Application no: 21/01750/DISC

Location: Phase 5C Parcel D2e Camp Road Heyford Park

Transport Development Control

The Applicant is seeking the discharge of condition 10 regarding the above application.

**Heyford Park Site Layout**

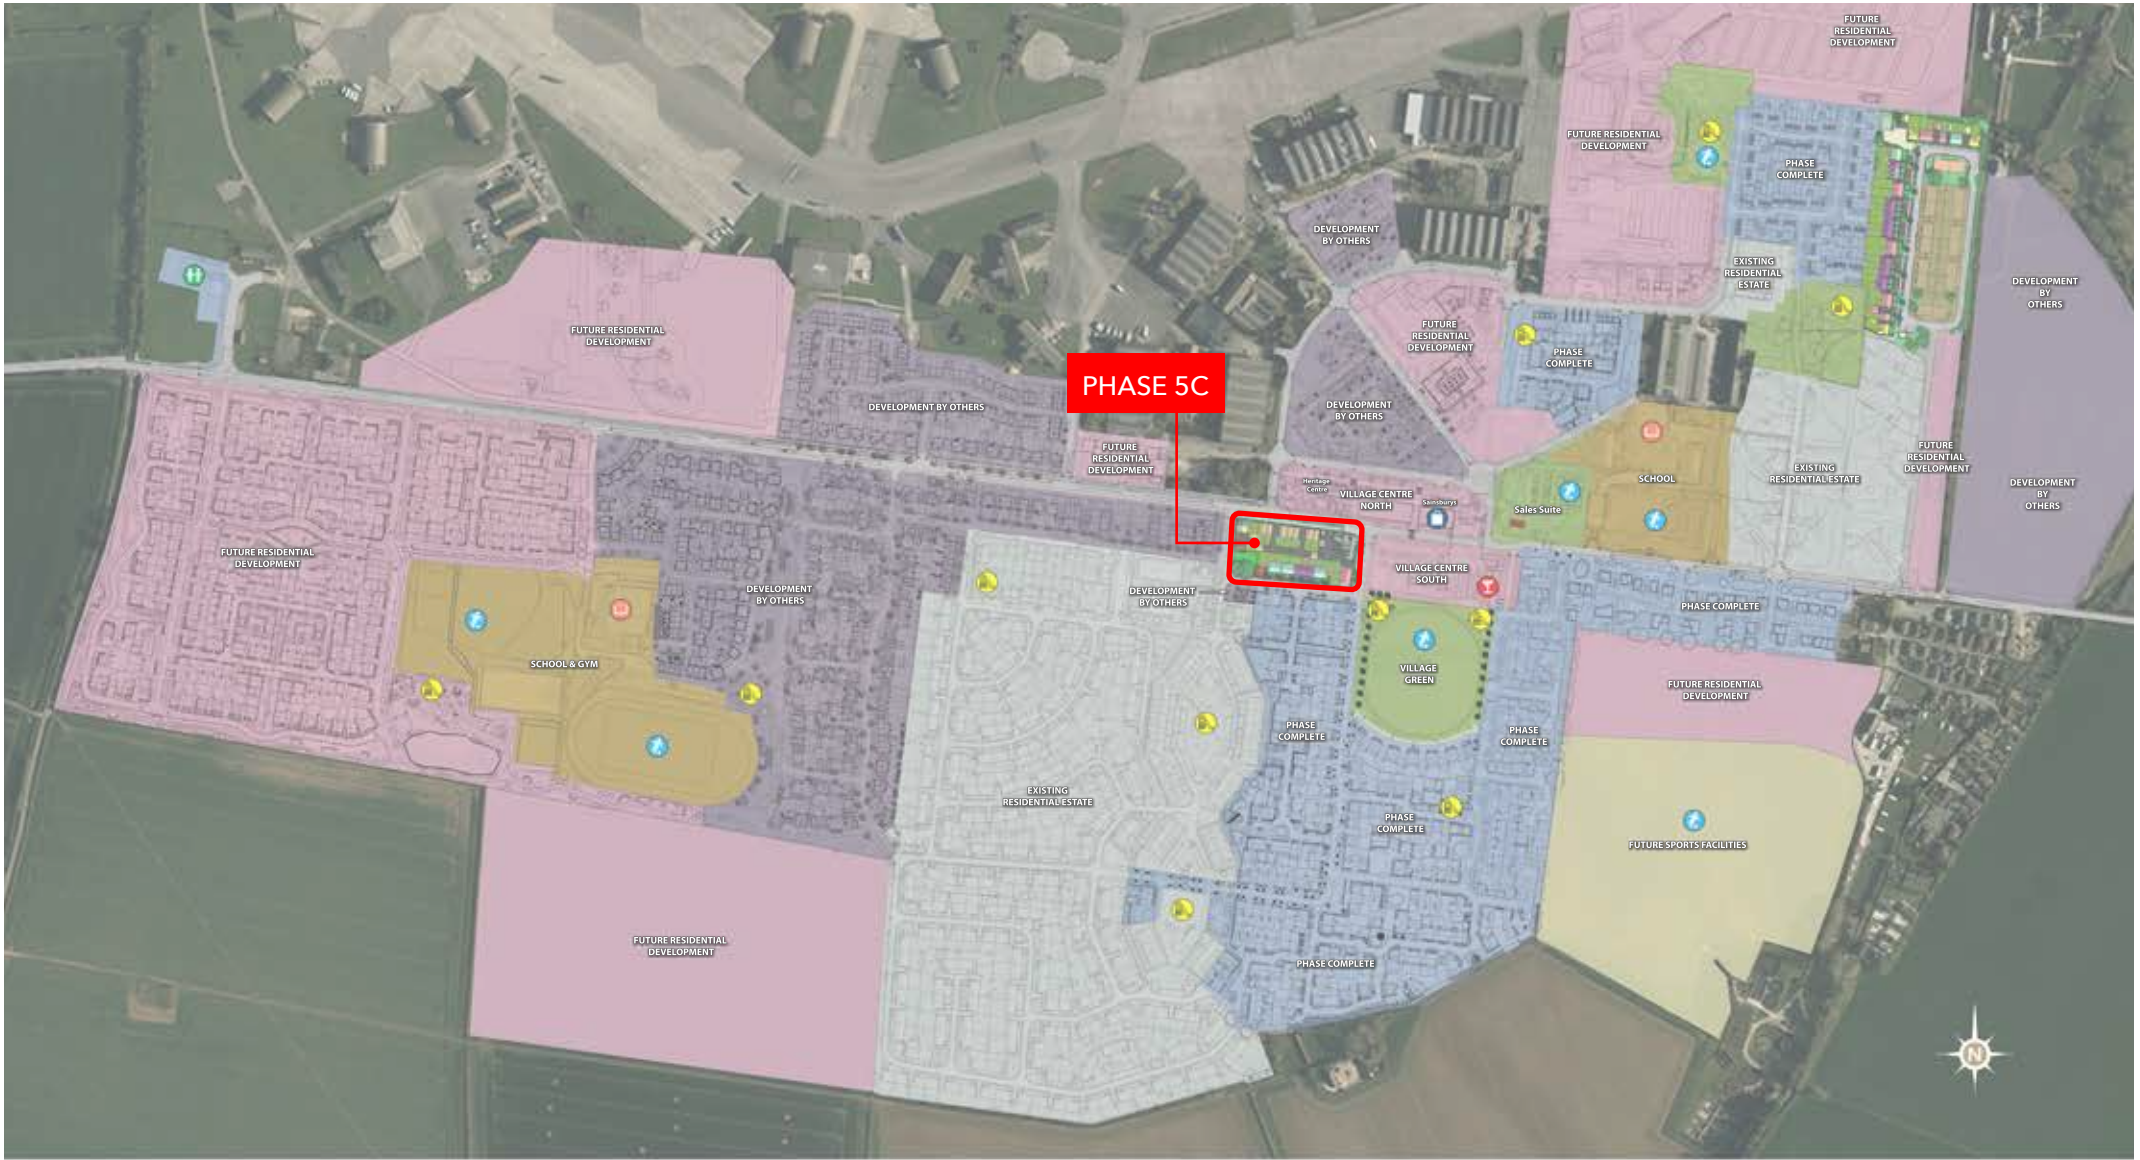
- Add the location of the site onto the site layout map. Make this clear.
- Section 2 – provide email addresses for the useful contacts.
- Section 3 – provide details on cycle parking.
- Section 5:
 - Detail key destinations and journey times.
 - Add a link to the [Railcards website](#).
- Add a section on EV charging.
 - Include [Park & Charge Oxfordshire](#).
- Add a section for local taxi companies.
- Add a section detailing supermarket delivery options.
